File: SF18/44253
Job ID: DOC18/329126
Your Ref: SSD 8874

RE: Heritage Council comments on Concept Application for Victoria Cross Over Station Development (SSD 8874)

**Figure 47:** Sketch up view of the indicative scheme for the Victoria Cross OSD looking south along Miller Street, showing the view towards the western (front) and northern elevations of the MLC Building provided by the 18m setback of the proposed OSD from the southern site boundary.

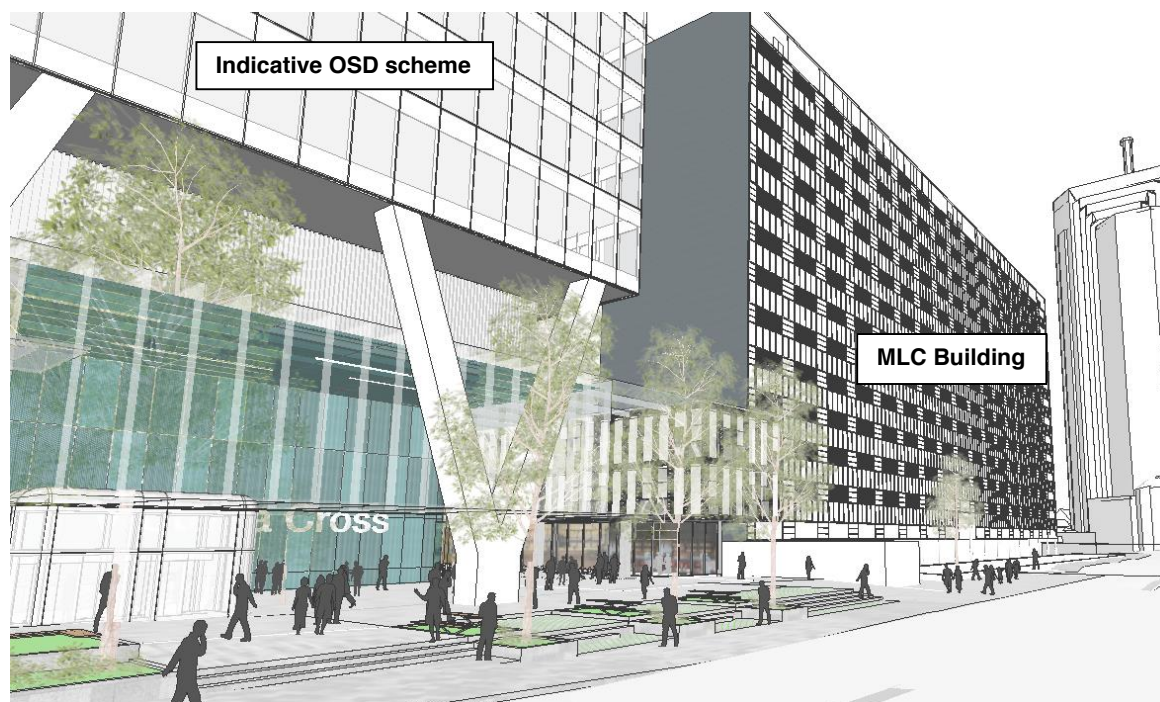
- It is acknowledged that the concept building envelope is setback from the street edge to provide a wide linear pedestrian space to the front of the building, and allowing views to the locally heritage listed MLC building. However, the building envelope does not align with the MLC building. It is recommended that the envelope be setback in line with the MLC building to preserve view lines and the context to the MLC building and the local heritage listed Rag & Famish Hotel.

**Figure 48:** Sketch up view of the indicative scheme for the Victoria Cross OSD looking south along Denison Street, showing the view towards the MLC Building.

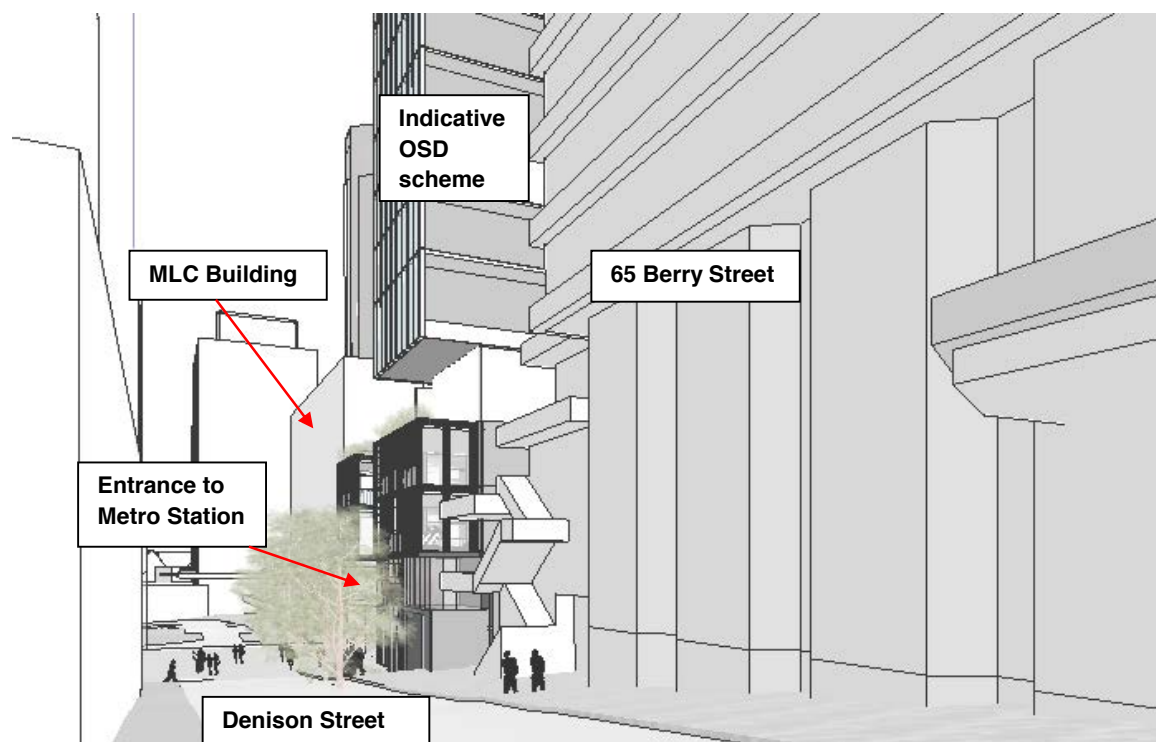
- The Denison Street frontage must ensure views to the MLC building are not adversely impacted.
- Consideration must be given to reducing the maximum building height envelope for the development to reduce adverse visual impacts to the surrounding State and local heritage places.
